WEST SUSSEX COUNTY COUNCIL CONSULTATION

TO:	Arun District Council FAO: Simon Davis
FROM:	Highways, WSCC
DATE:	04/09/2018
LOCATION:	1, Finch Gardens, Bersted, PO22 9EQ
SUBJECT:	BE/74/18/PL Erection of 1 No. attached dwelling. Further comments.
DATE OF SITE VISIT:	
RECOMMENDATION:	☐ Advice ☐ Objection ☒ Modification ☐ No Objection ☐ More Information ☐ Refusal
S106 CONTRIBUTION TOTAL:	£N/A See below for breakdown.

CLIENT	PROJECT	TITLE	STATUS	DRAWN BY	REVIEWED BY
KELLY WESSON	1 FINCH GARDENS NORTH BERS TED	ATTACHED DWELLING PROPOSED FL DOR PLANS	PLANNING	SJ	SJ
			DATE	SCALE	
			13.06.2018	1:50@A1	
			DRAWING NUMBER		
			ADC/9/18 – 14

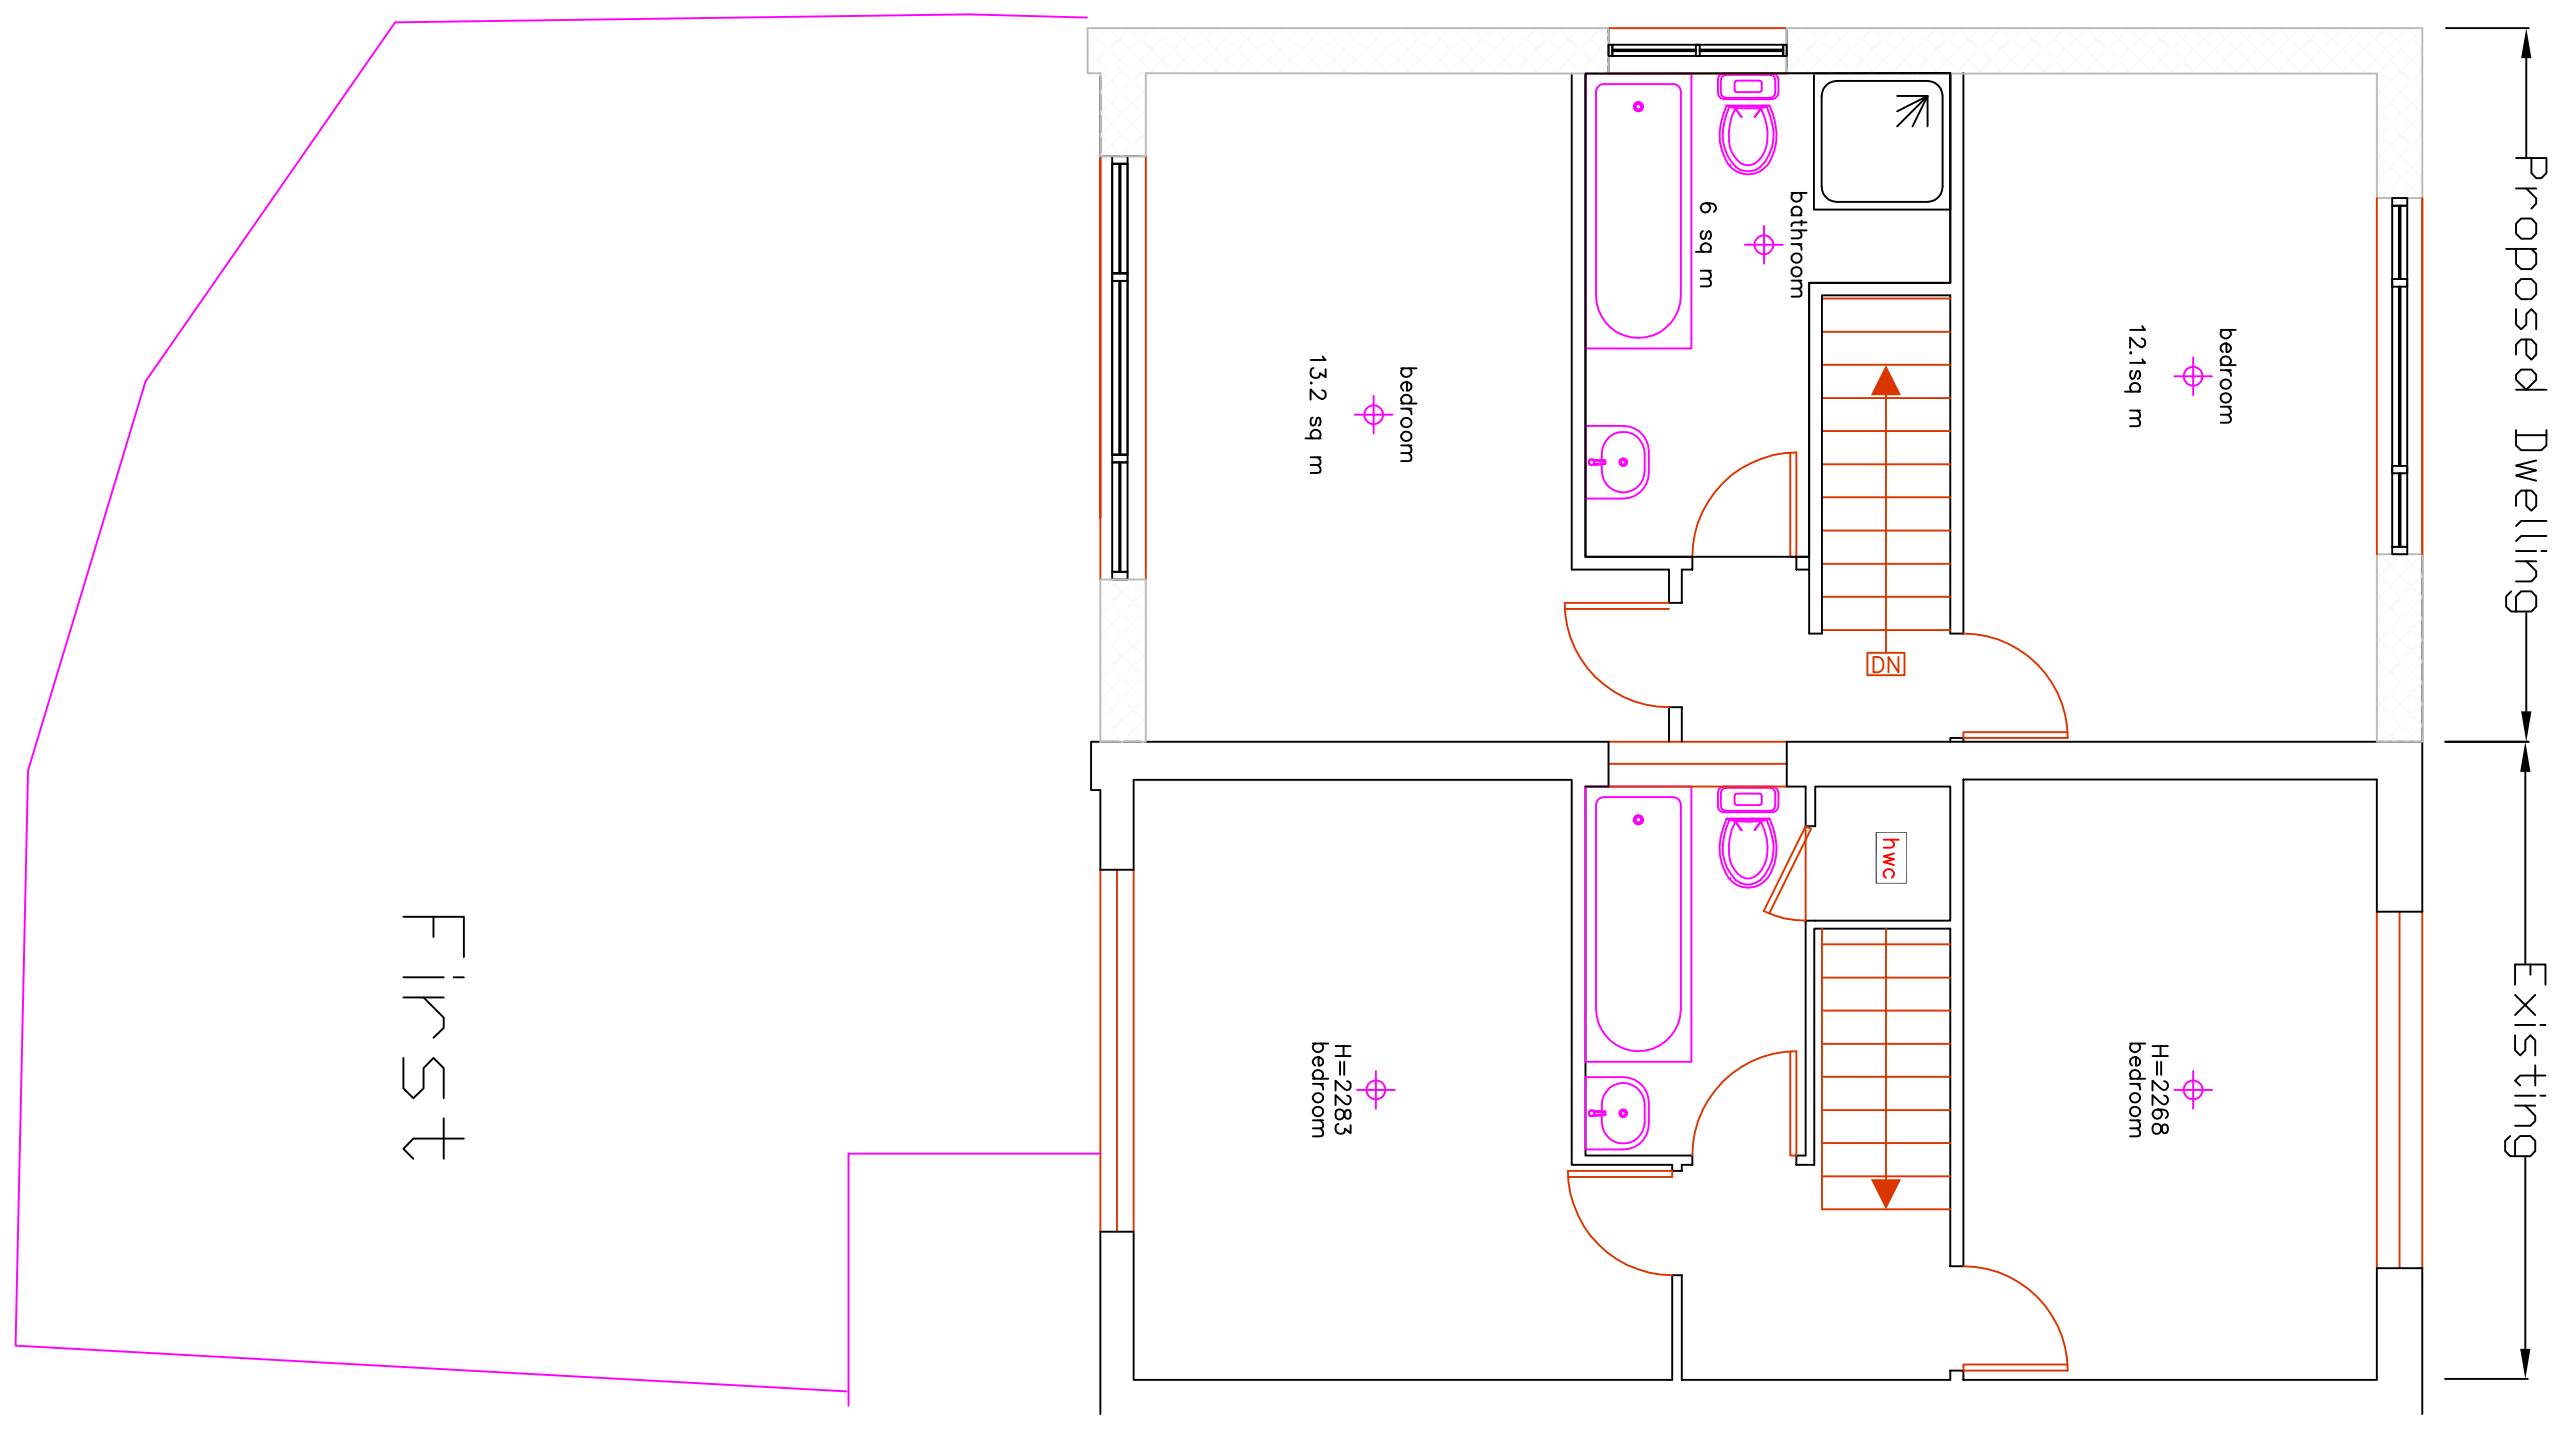
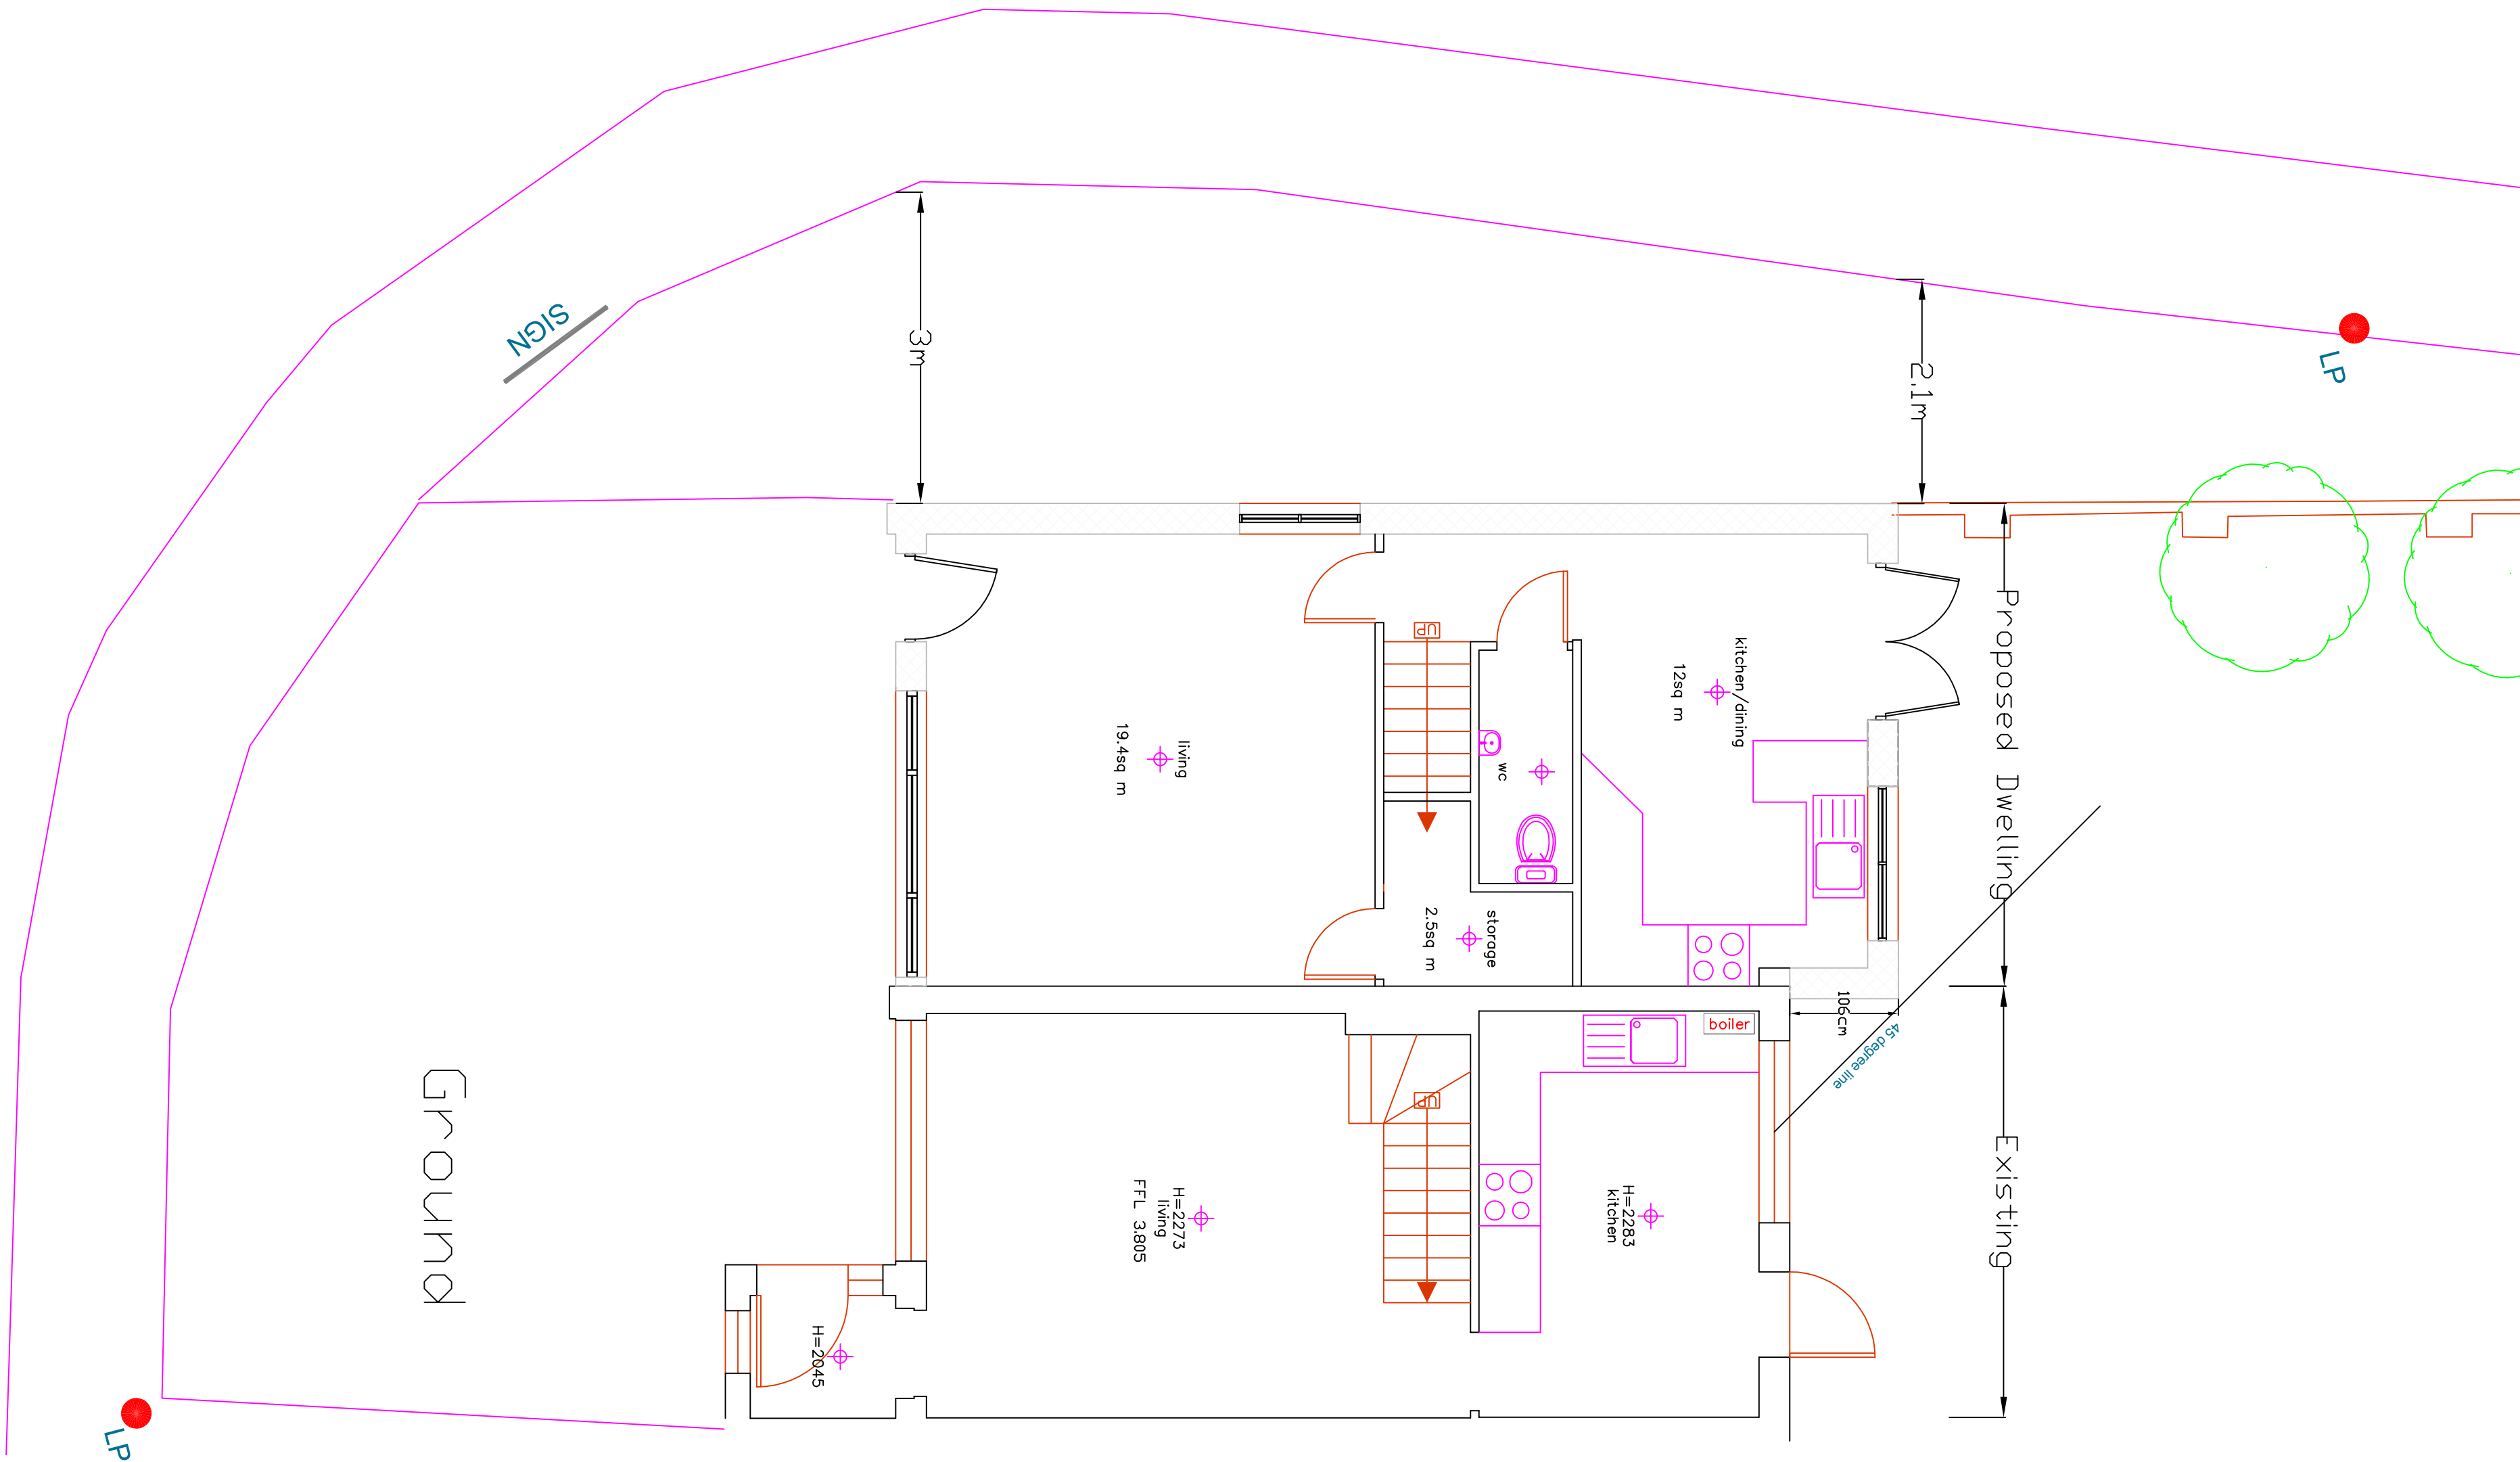
The applicant has now shown the extent of the proposed dropped kerb. As the proposed dropped kerb is greater than the maximum width of 6.4m the local area office were consulted and have provided the following comments:

We only permit a total access width of 6.4m maximum (7kerbs). The site appears to be served by an existing 4.5m access and therefore we would normally permit an extension of this to 6.4m. An access across the whole frontage would appear to be around 11 kerbs (approx. 10m).

The lamp column would need to be moved to accommodate the access directly at the front of the existing property. Given the existence of crossings serving the neighbouring properties, I can't see a suitable alternative location that would be within the WSCC lighting design standards.

From the above comments it would appear unlikely that a license for the vehicle cross-over (VCO) works would be permitted with the proposed layout. The LHA would advise the applicant to consider a modification to the proposed access.

The applicant should provide a scaled plan demonstrating a modified access to reflect the local area offices' comments. Once this additional information has been provided, the LHA should be re-consulted.
